## Meeting note

<b>Project</b>	AQUIND Interconnector
<b>File reference</b>	EN020022
<b>Status</b>	<b>FINAL</b>
<b>Author</b>	The Planning Inspectorate
<b>Date</b>	28 August 2019
<b>Meeting with</b>	Aquind
<b>Venue</b>	Telecon
<b>Meeting objectives</b>	Project update meeting and review of draft documents
<b>Circulation</b>	All attendees

### Section 51 Advice – draft Application Document by AQUIND Limited for PINS review

**AQUIND Interconnector
Hedgerow and Tree Preservation Order Plans**

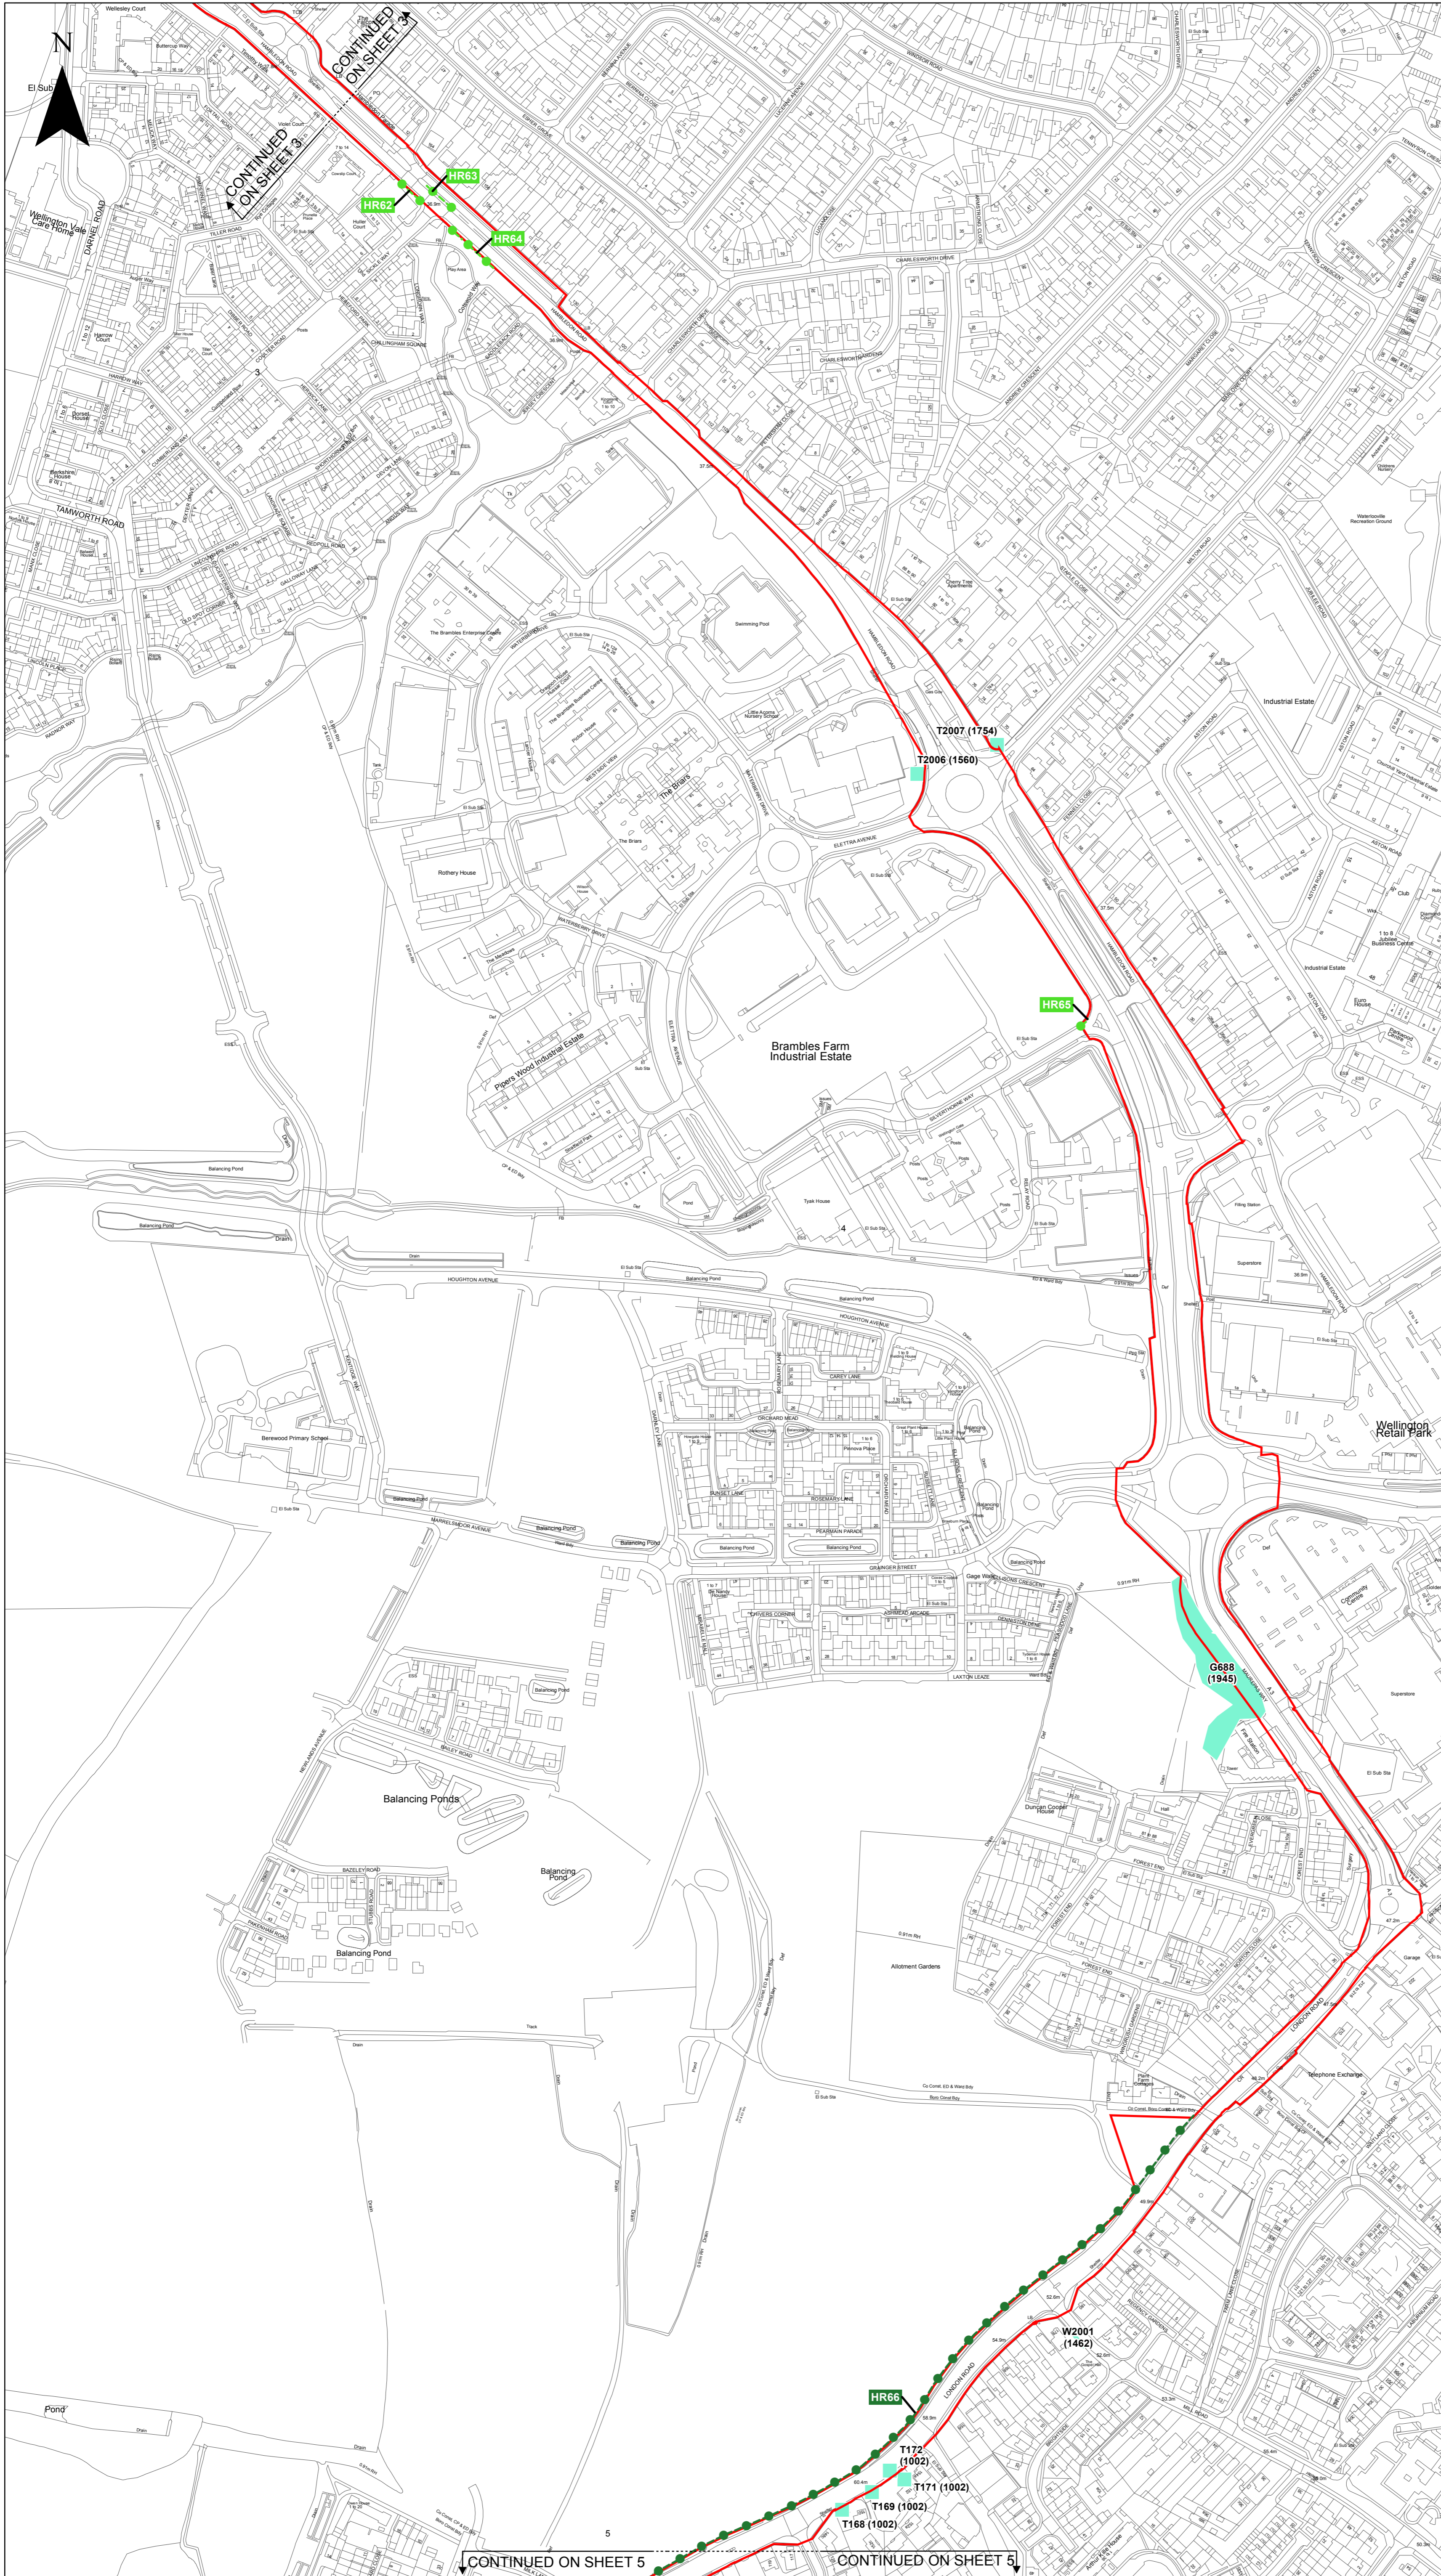
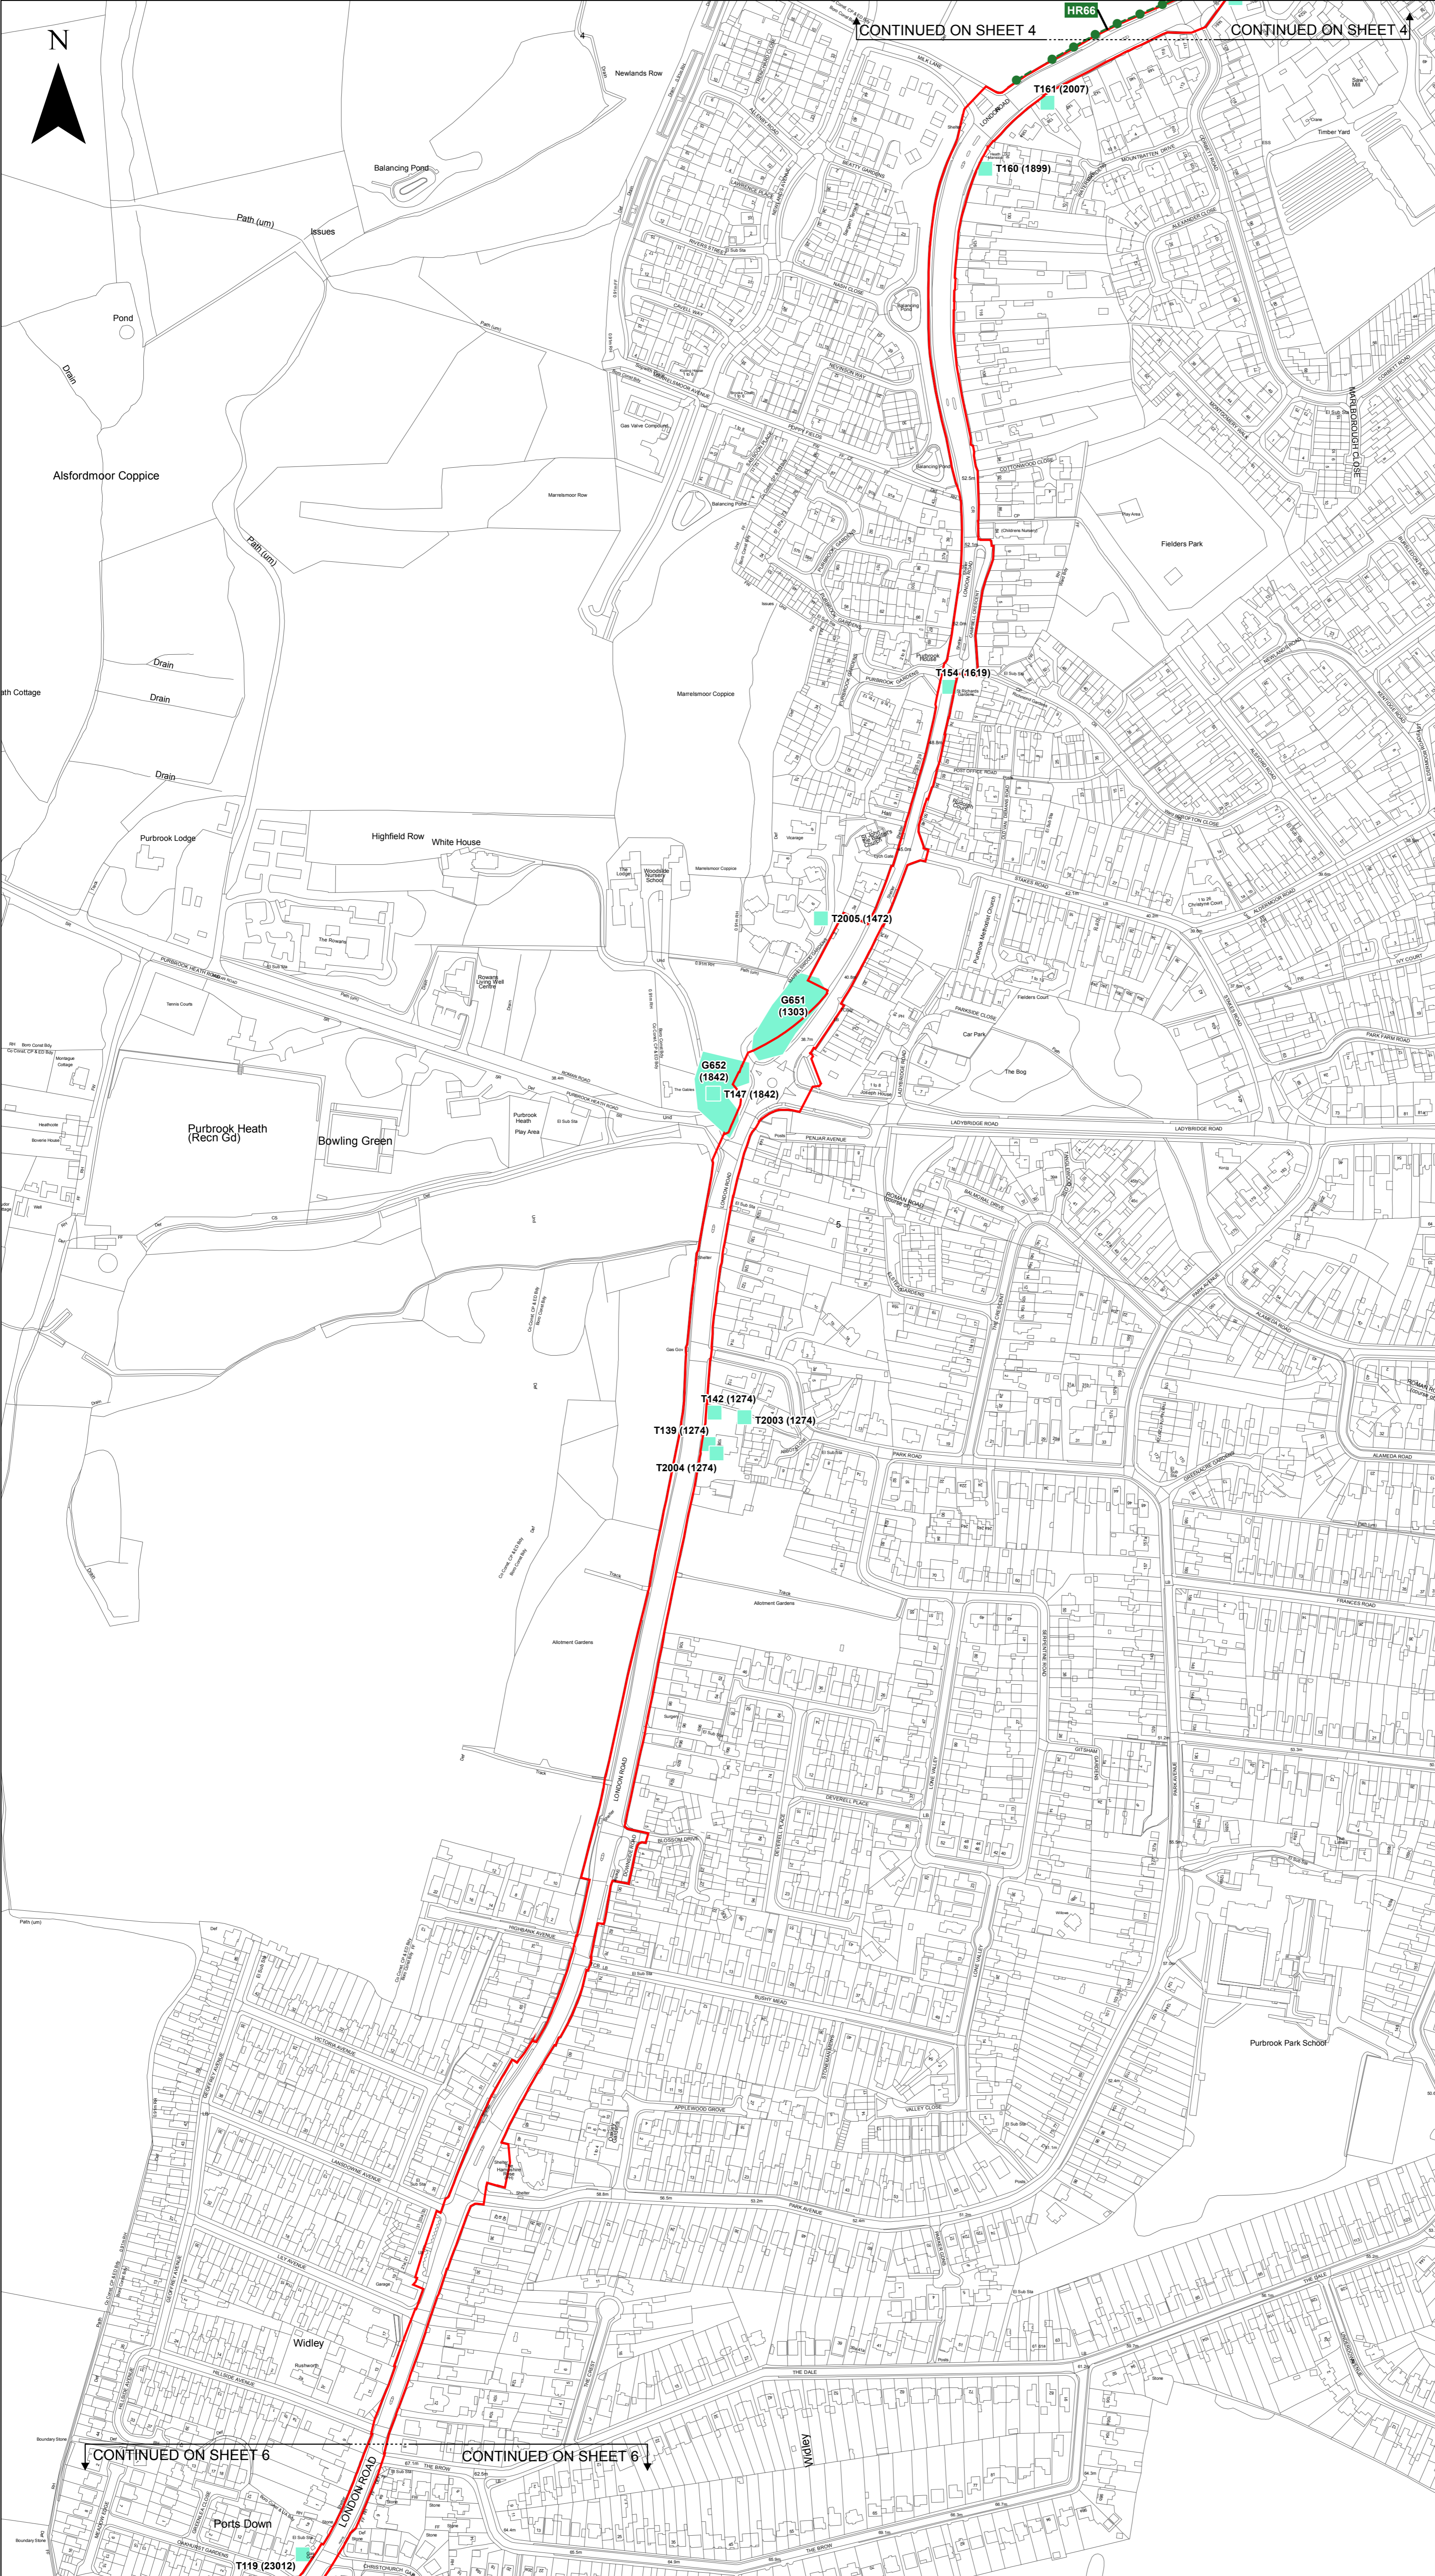
12.	Article 40(4)(a)	Felling or lopping of trees [and removal of hedgerows]	Please refer to AN15 where it states that 'Hedgerows affected by the Proposed Development should be identified in a Schedule to and on a plan accompanying the draft DCO. The Schedule and plan could also helpfully identify those hedgerows that are 'important' hedgerows.

Draft Development Consent Order			
Q No.	Article (A)/ Requirement (R)	Extract from DCO (for ease of reference)	Comment/Question
			Therefore it is advised that all hedgerows are identified in a schedule, and not just important hedgerows.
